KITTITAS COUNTY COMMUNITY DEVELOPMENT SERVICES

RE: Otte Boundary Line Adjustment, BL-11-00024

Map Number 18-18-25053-0002 Parcel Number 10877
Map Number 18-18-25053-0007 Parcel Number 955001

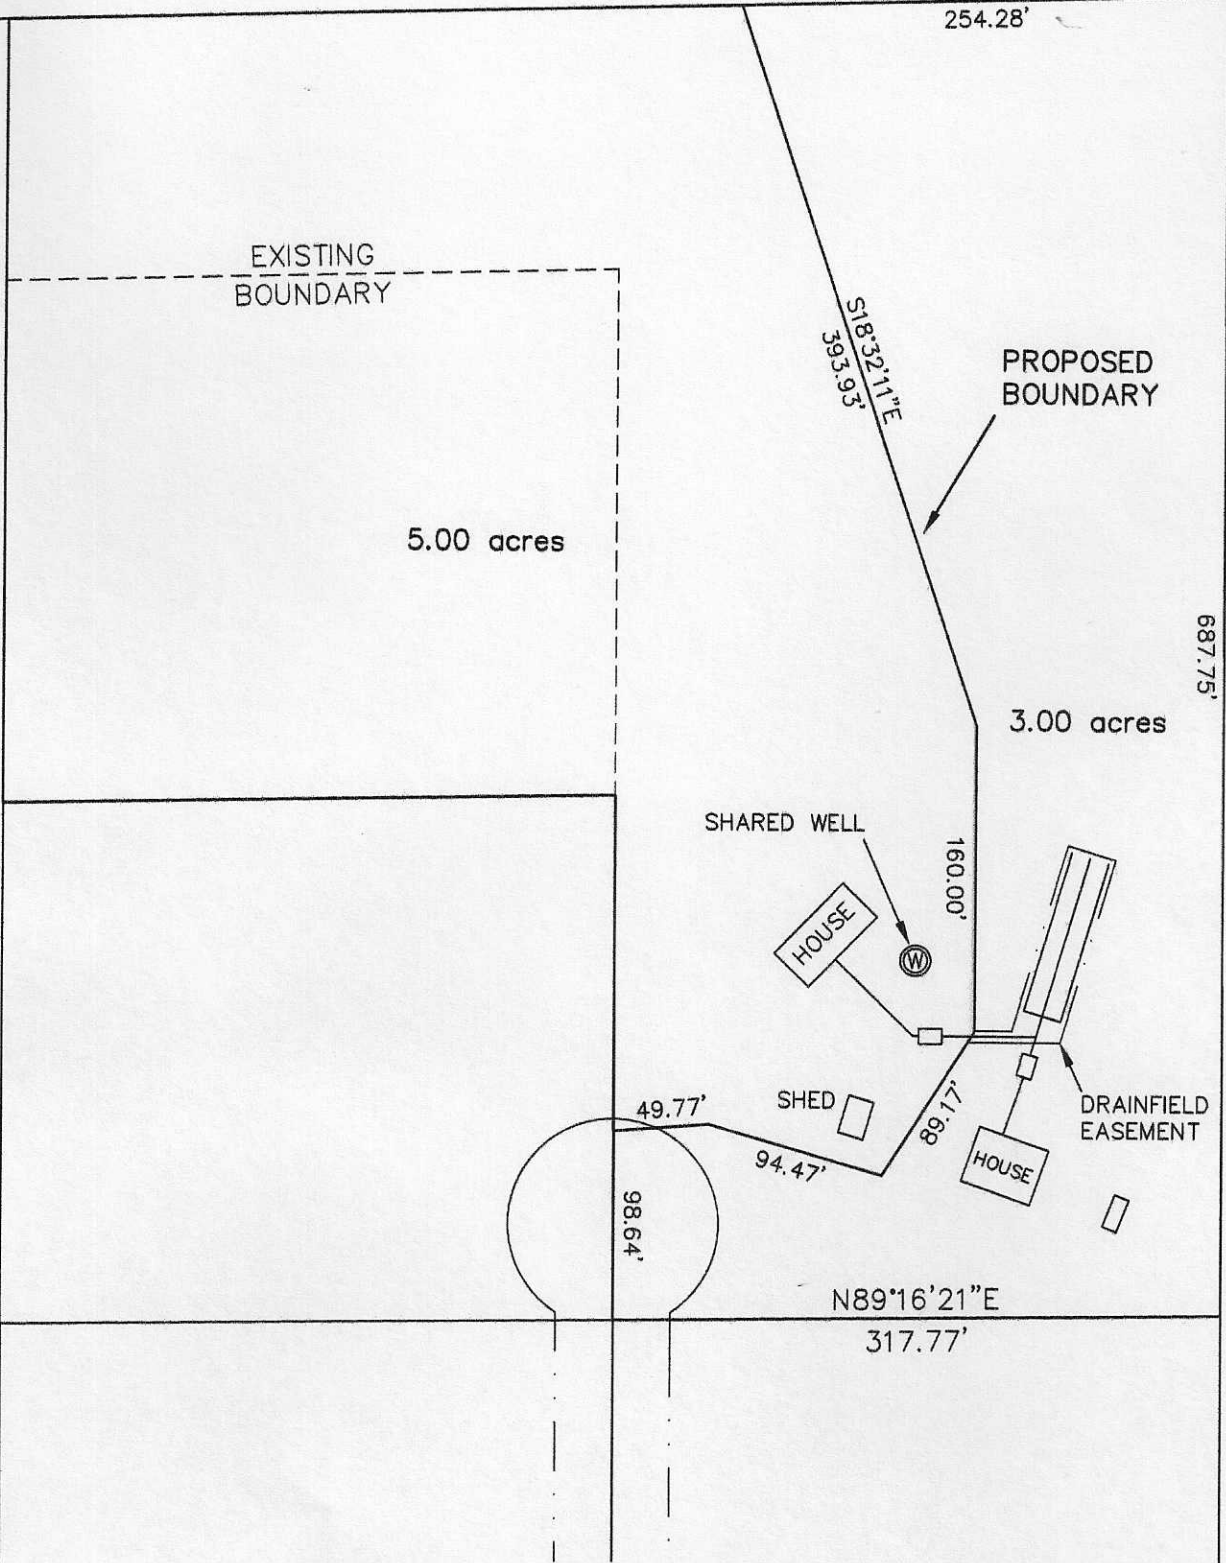
Since this is a shared well between the two lots the 50 foot setback from the property line is not an issue. I am not sure how the drainfield got within the 100 foot radius.

50 feet. The existing well isn't even 100 feet from the existing drainfield.

Is there a scale for the drawing so I know how far the proposed lot line is from the well?

I also have questions on this one. It appears that the proposed project will have a lot line going through the area where the house, well site and drainfield might be. I need a better site plan showing the location of the well and on-site sewage system in relation to the proposed lot line. Can the applicant provide this?

This took a little while but the attached exhibit shows the existing utilities and where both parties would like the revised boundary to end up. Currently there is one well and one drain field that serves both residences. They have agreed to share these utilities and can record the necessary easements and shared well agreements once they have received the conditions for final approval. Please review and contact me back with any questions or concerns.
